## El Paso County Park Advisory Board

### Agenda Item Summary Form

**Agenda Item Title:** Grandview Reserve Phase III PUD Development Plan and Preliminary Plan

**Agenda Date:** June 12, 2024

SHEET **CV** 01

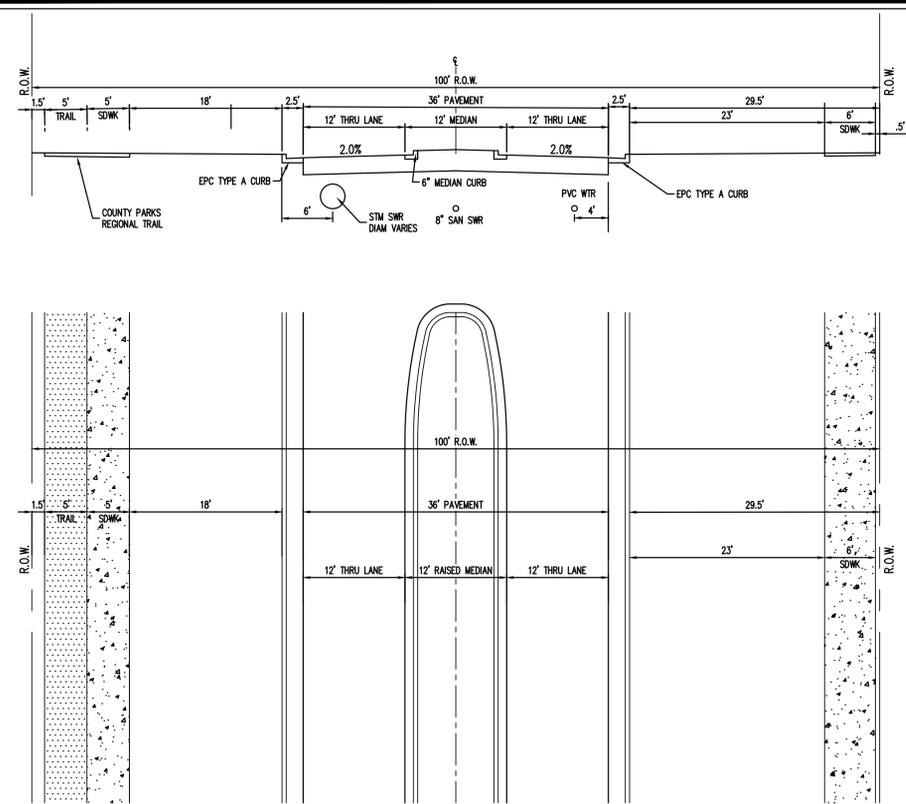
However, the Land Use Table shown on the first page of the PUD Development Plan and Preliminary Plan, however, does not properly list all the available open space, and only highlights the neighborhood park tracts, thus inaccurately showing that the project does not meet the Land Development Code's 10% open space requirement. Staff highlighted and calculated all tracts that meet the definition of open space, which include the neighborhood parks, passive open space, trail corridors, and landscape areas. Staff spoke with the applicant's representative, and they verified the staff's findings. As such, the application has met and exceeded the 10% open space requirement.

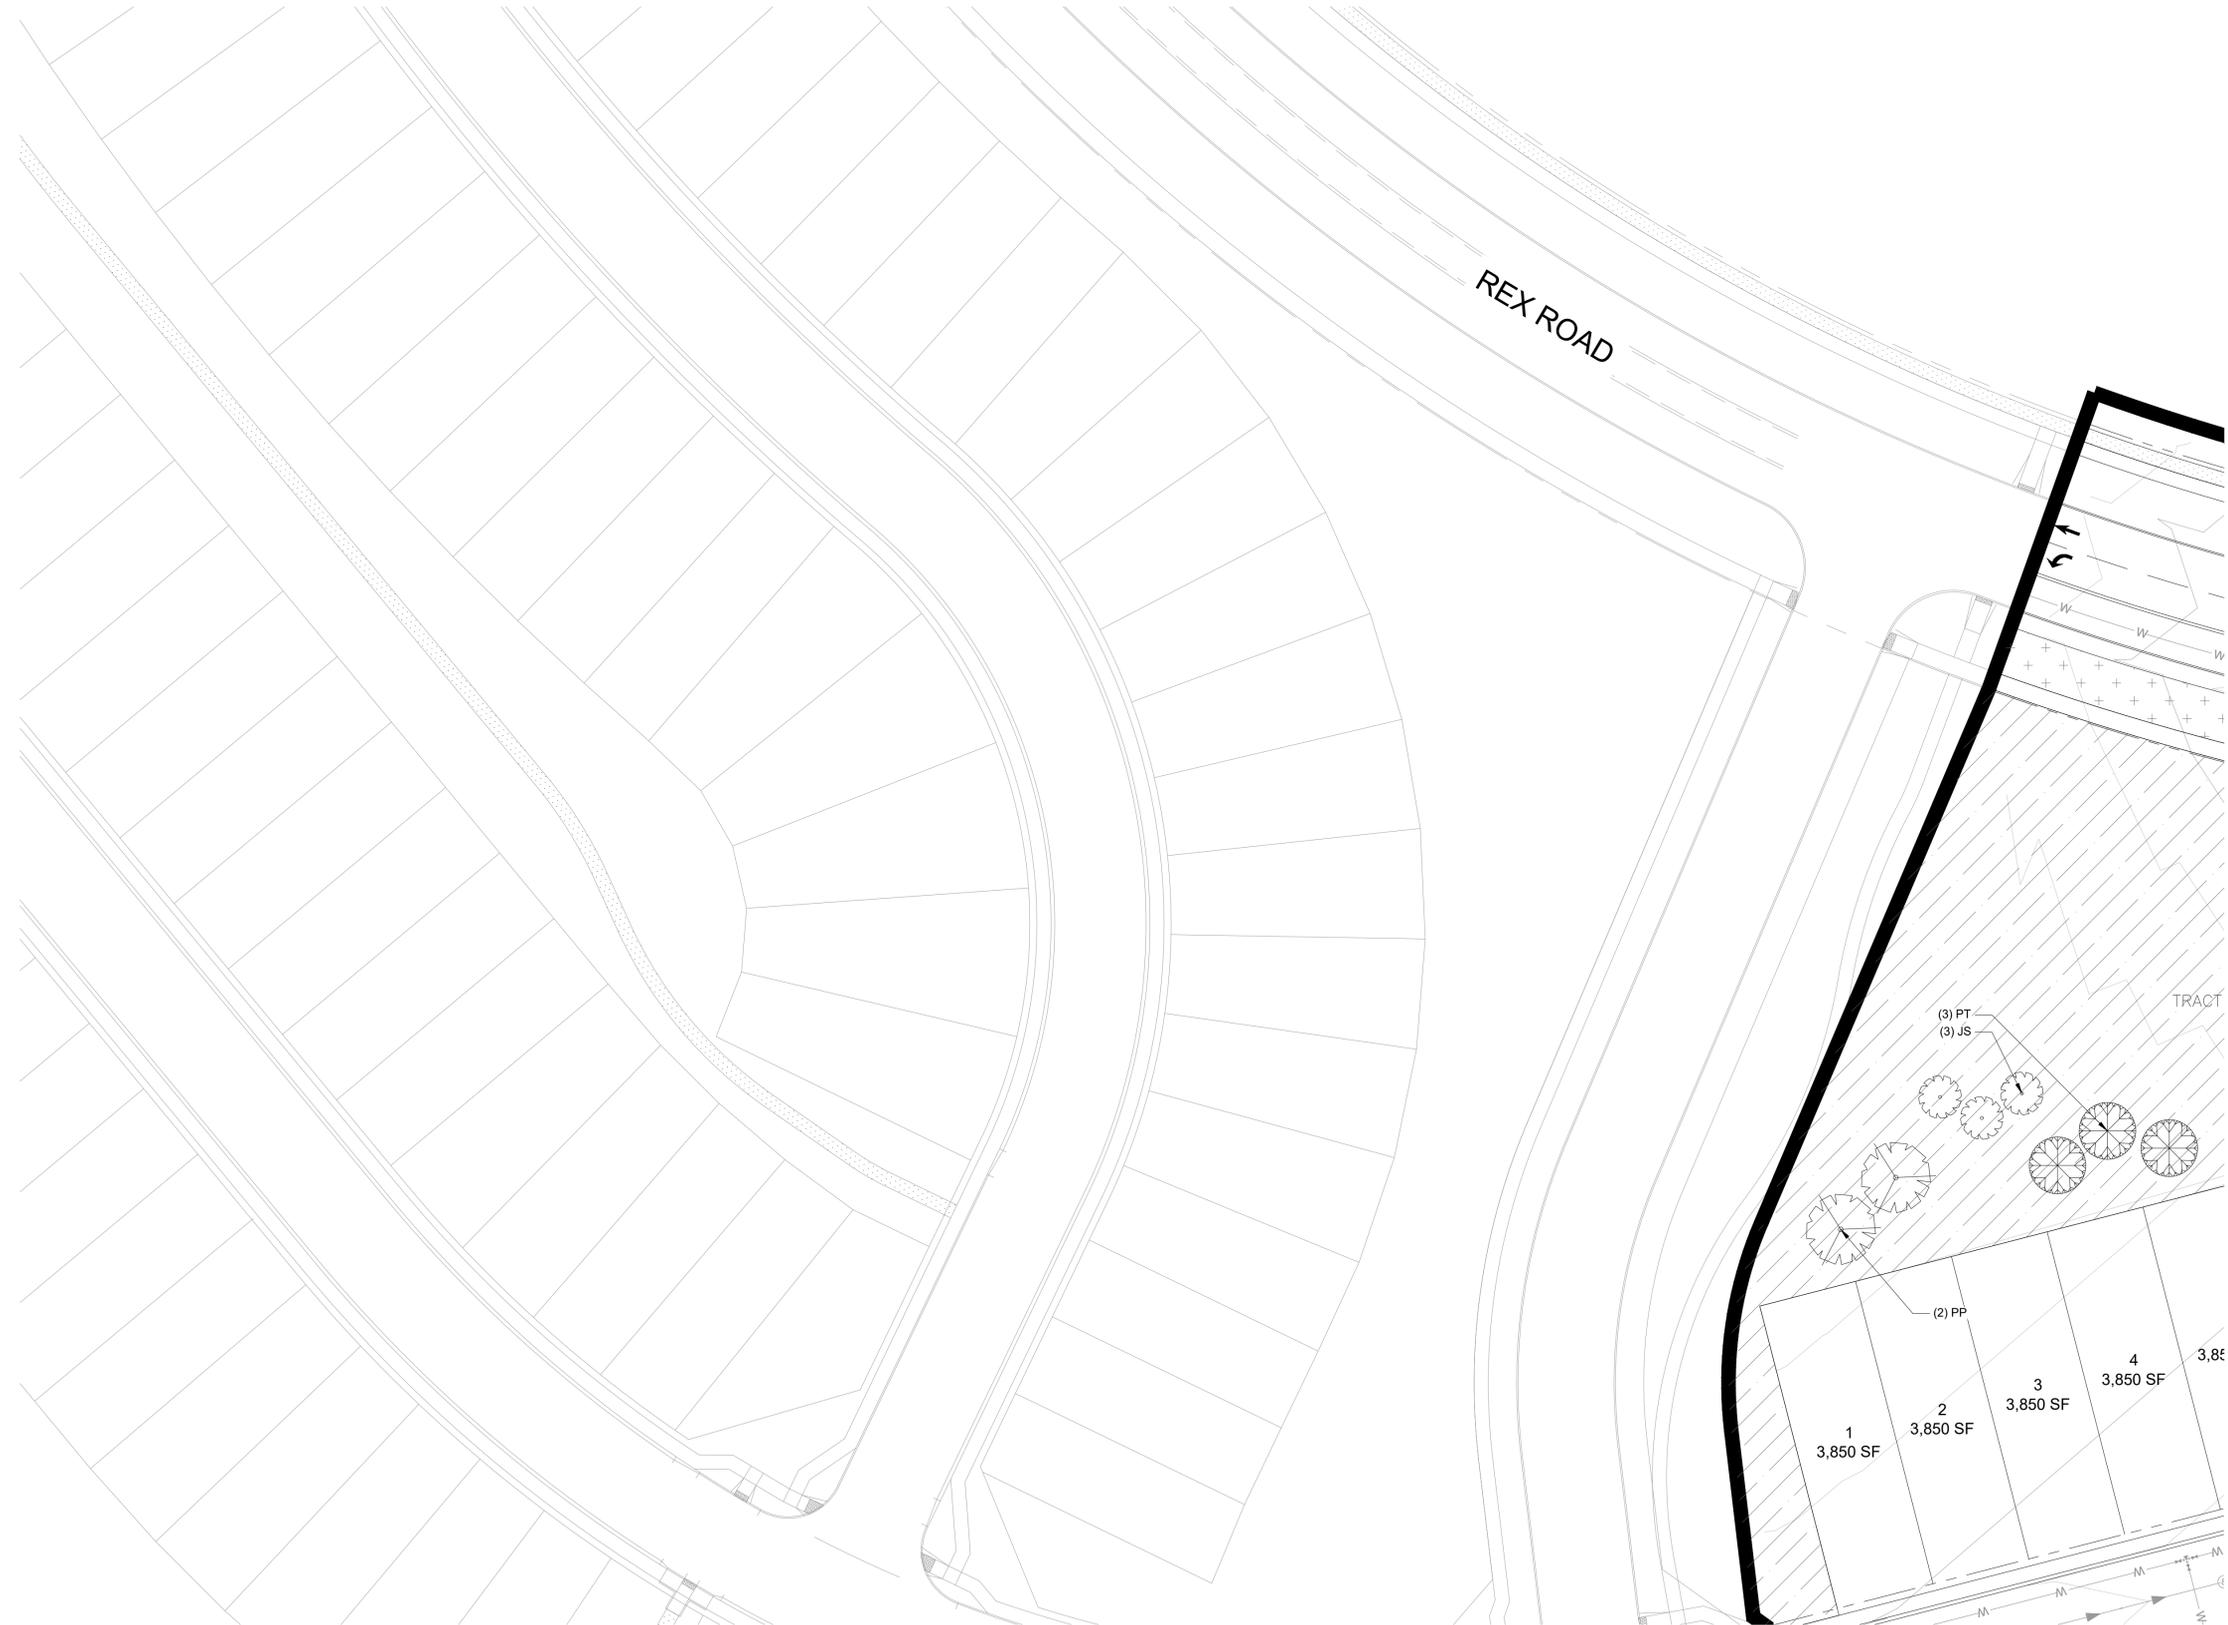
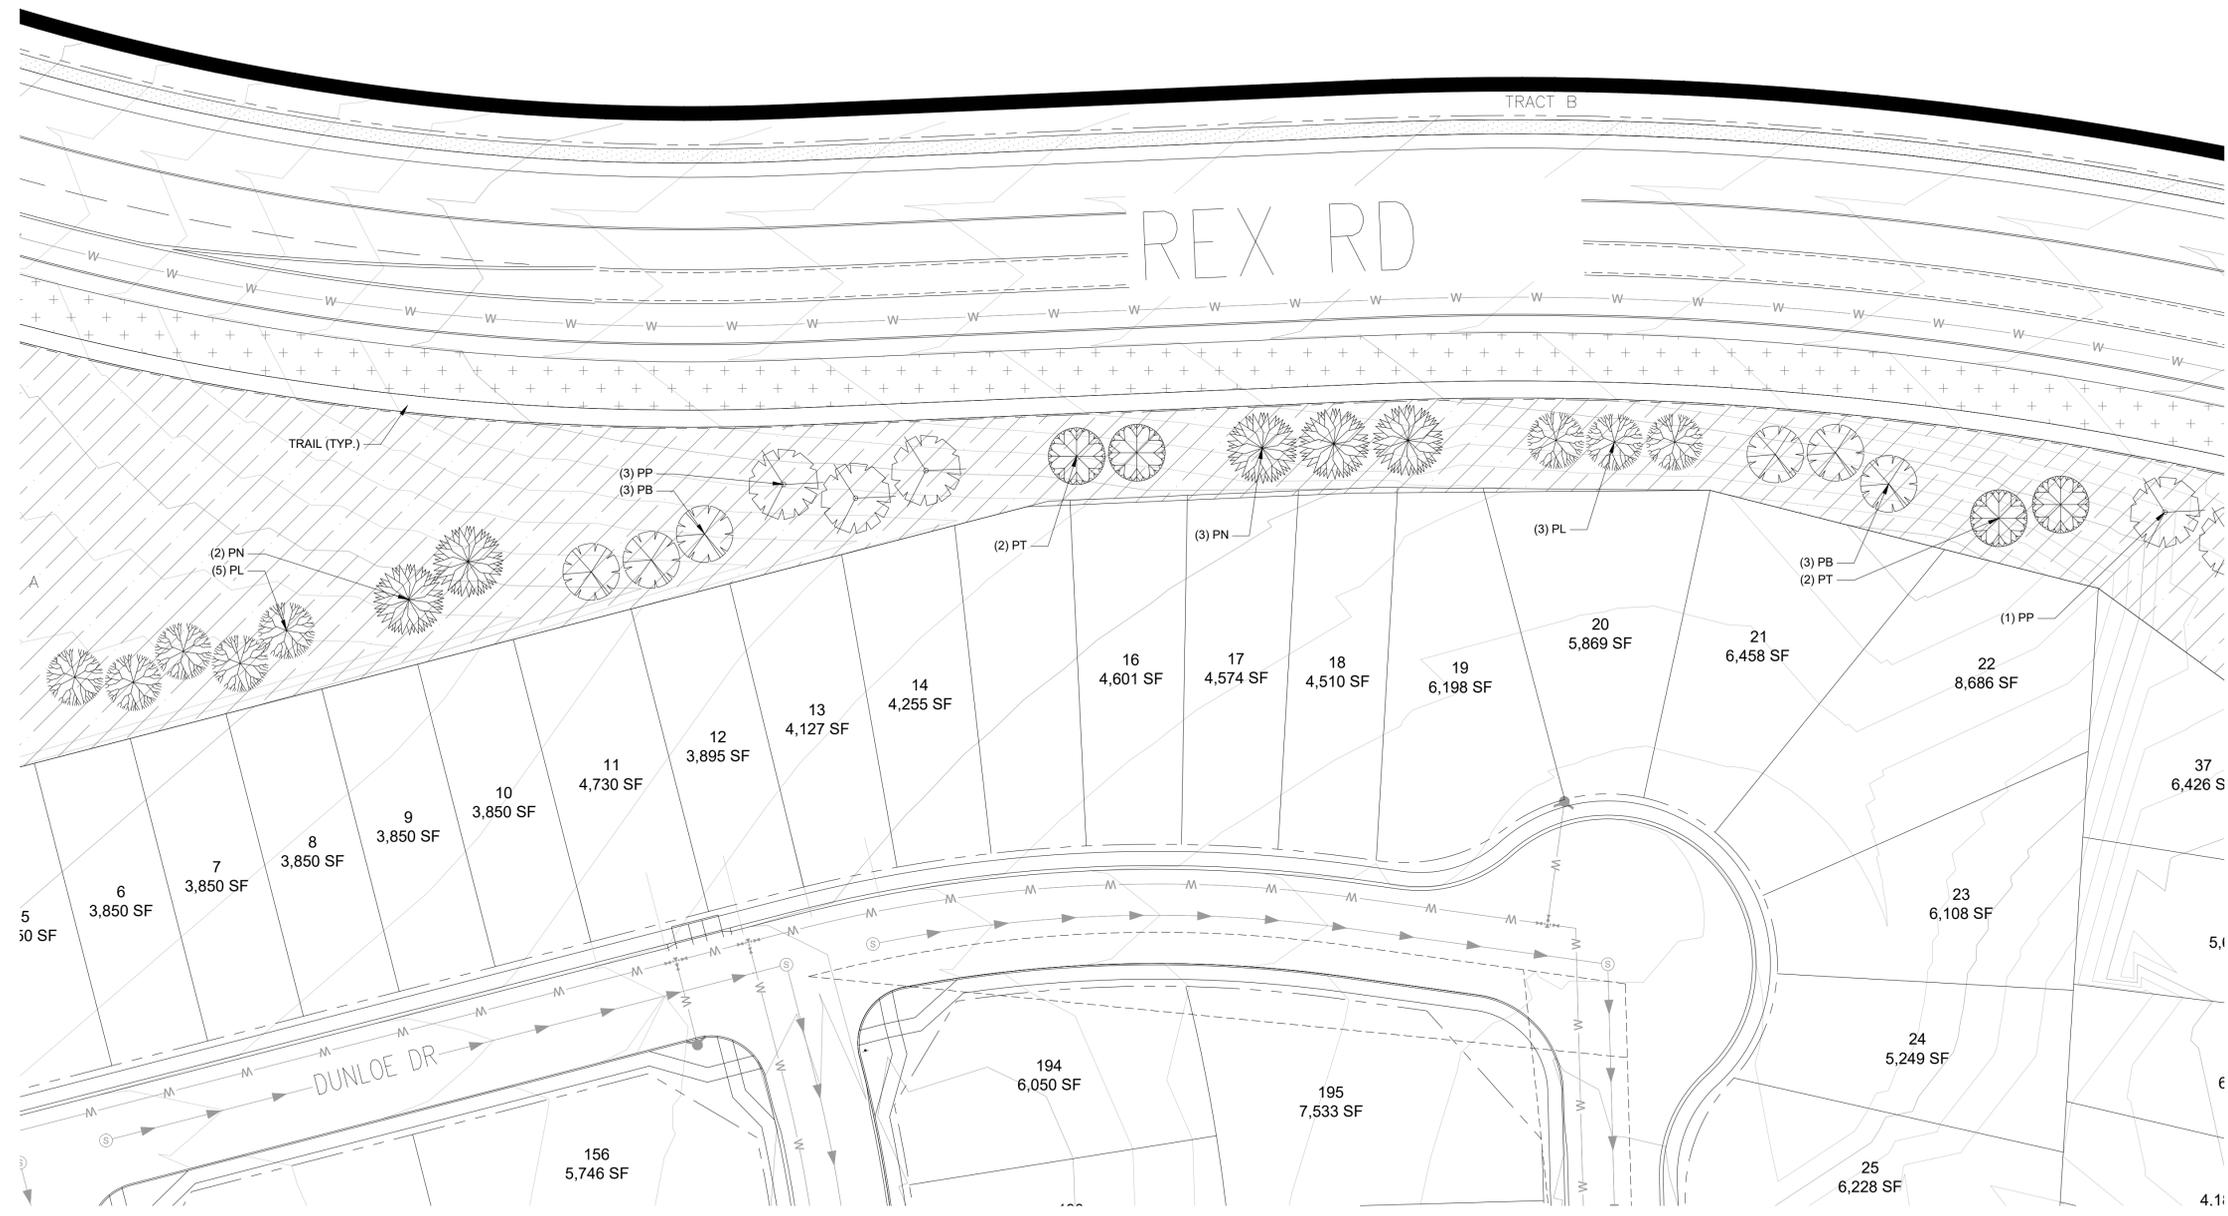
EPC staff is encouraged by the applicant's willingness to provide extensive recreational amenities for its residents of Grandview Reserve and citizens of El Paso County through the development of an expansive and connected park, trail, and open space system. Staff recommends that the applicant submit detailed site plans for the proposed neighborhood parks and include multi-generational recreational amenities such as a playground, multi-use turf field, and/or seating and picnic areas. The submitted Landscape Plans are rather limited and only show half of the proposed park area located in Tract I.
